State of Washington
Department of Fish and Wildlife

RE: WDFW comments on Canyon Interpretive Center Proposal

SD-14-00004 Canyon Interpretive Center

1 SITE PLAN
1" = 80'-0"

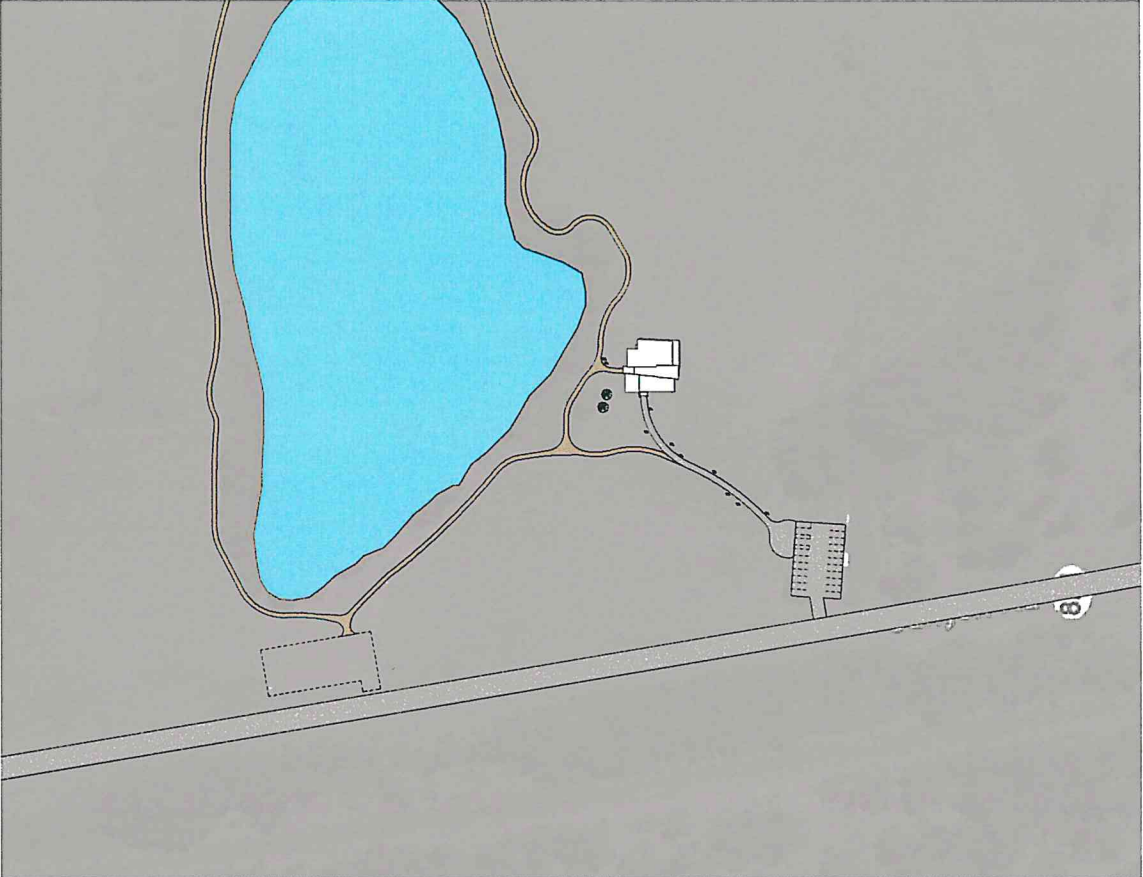
We have concerns that the heat pump coils that will be placed in the pond will have unintended and negative impacts by increasing water temperatures in the spring and summer months. Additional thermal loading to the pond from the heat pump coils may raise water temperatures above the lethal limits for rainbow trout earlier in the season than they would normally occur. We also want to ensure that public fishing access is maintained and not restricted by the coils or construction and maintenance of the coils. We would like to see a thermal impact study for the heat pump coils to ensure that they will not have an adverse impact on water temperatures and subsequently the put and take trout fishery in Helen McCabe Pond.

It is unclear from the narrative and drawings where and how fill will be placed in Helen McCabe Pond. Please provide more detailed drawings for how construction of the heat pump coils and heat pump piping will be constructed through the riparian shoreline area and into the pond. Include the type of anchoring required and how deep the coils will be

in the water. Will soil and rock be used to cover the pipe leading to the underwater coils? If so, how will water quality (turbidity) be addressed during construction? Please avoid native riparian vegetation to the greatest extent possible and provide a restoration plan for short term and long term revegetation of the riparian vegetation around the heat pump pipes. Care should be taken to avoid spreading invasive plants such as Eurasian milfoil and yellow flag iris during construction.

We would prefer alternatives to placing the heat pump coils directly into the pond. It may be possible to dig a shallow pit separate from the pond for the coils. This would eliminate our concerns about water quality impacts and fishing access impacts to Helen McCabe Pond.
